15 December 2023

**Re: SSD-8996 – Mod 1 - Loreto Normanhurst - 91-93 Pennant Hills Road and 6-12 Mount Pleasant Avenue, Normanhurst – Response to latest amendment**

Earthscape Horticultural Services
Arboricultural and Horticultural Consultants
PO Box 364
BEROWRA NSW 2081
Ph: 02 9456 4787
Fax: 02 9456 5757 e: earthscape@iinet.net.au

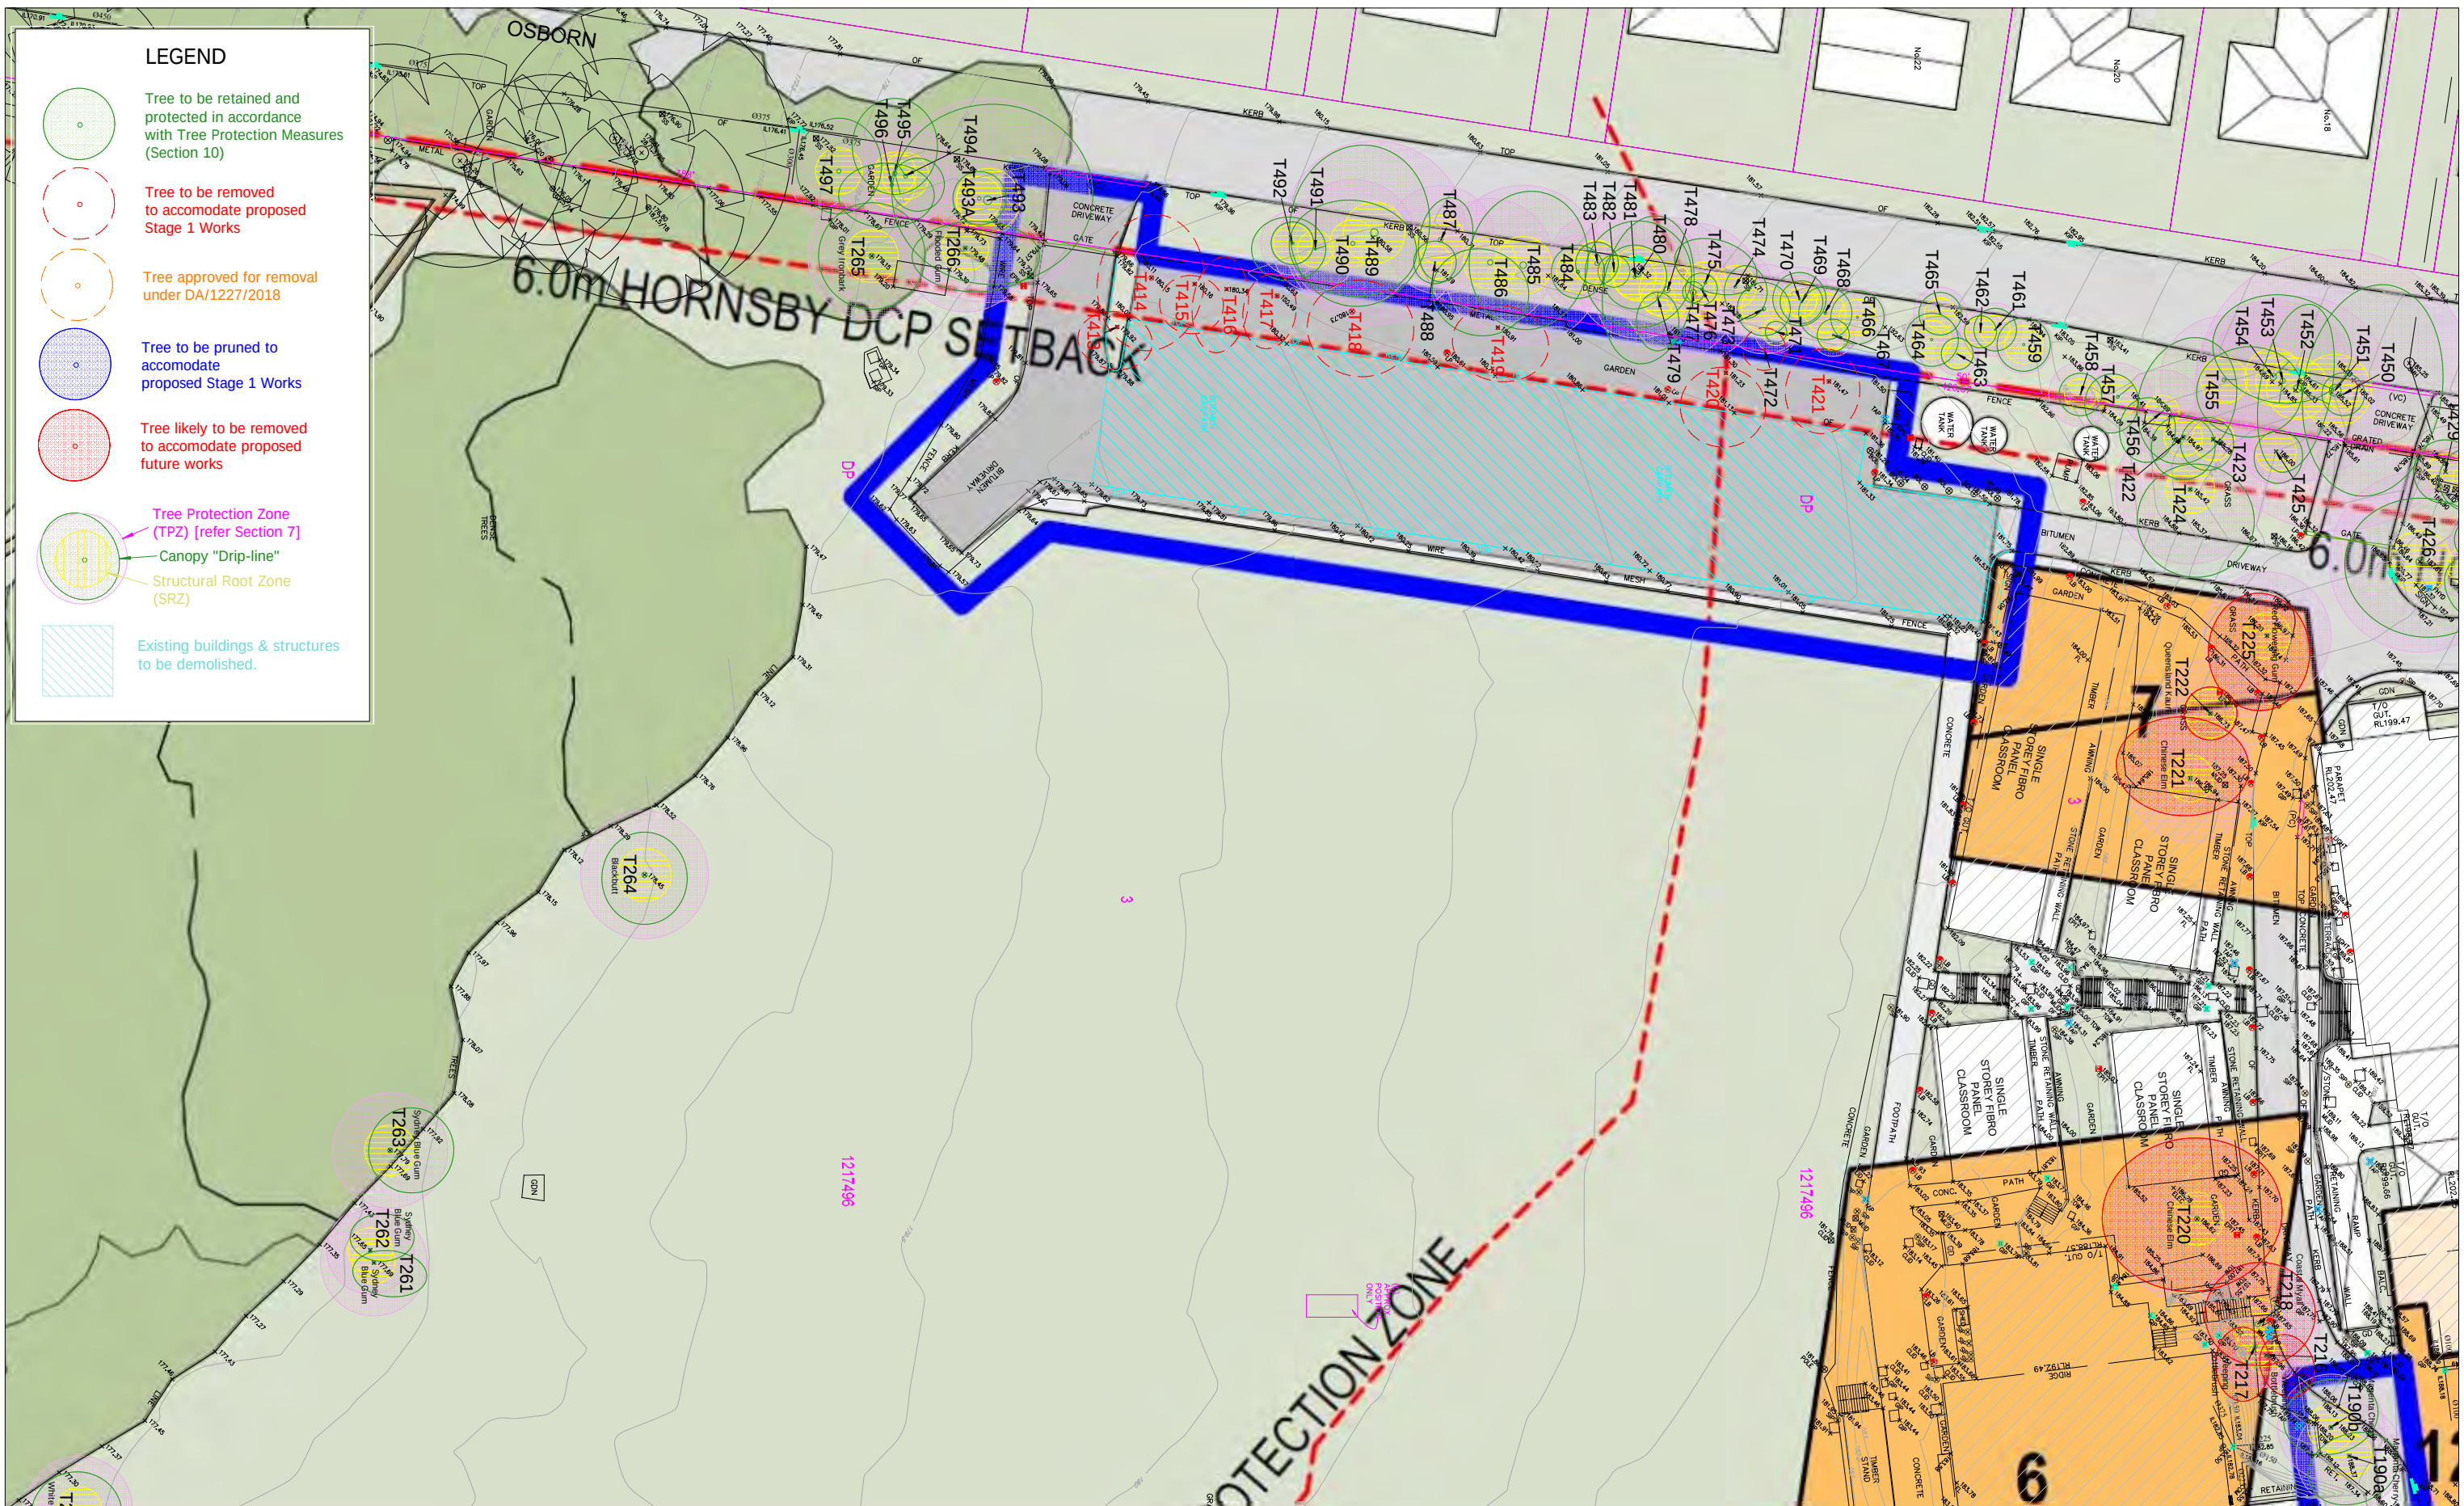
- Numerous trees are plotted for removal to accommodate fill batter for a pedestrian pathway and driveway ramp. It is suggested the Department review retaining more of these trees by utilising sensitive tree construction techniques and utilising different construction materials/techniques such as pier and beam instead of fill batter.
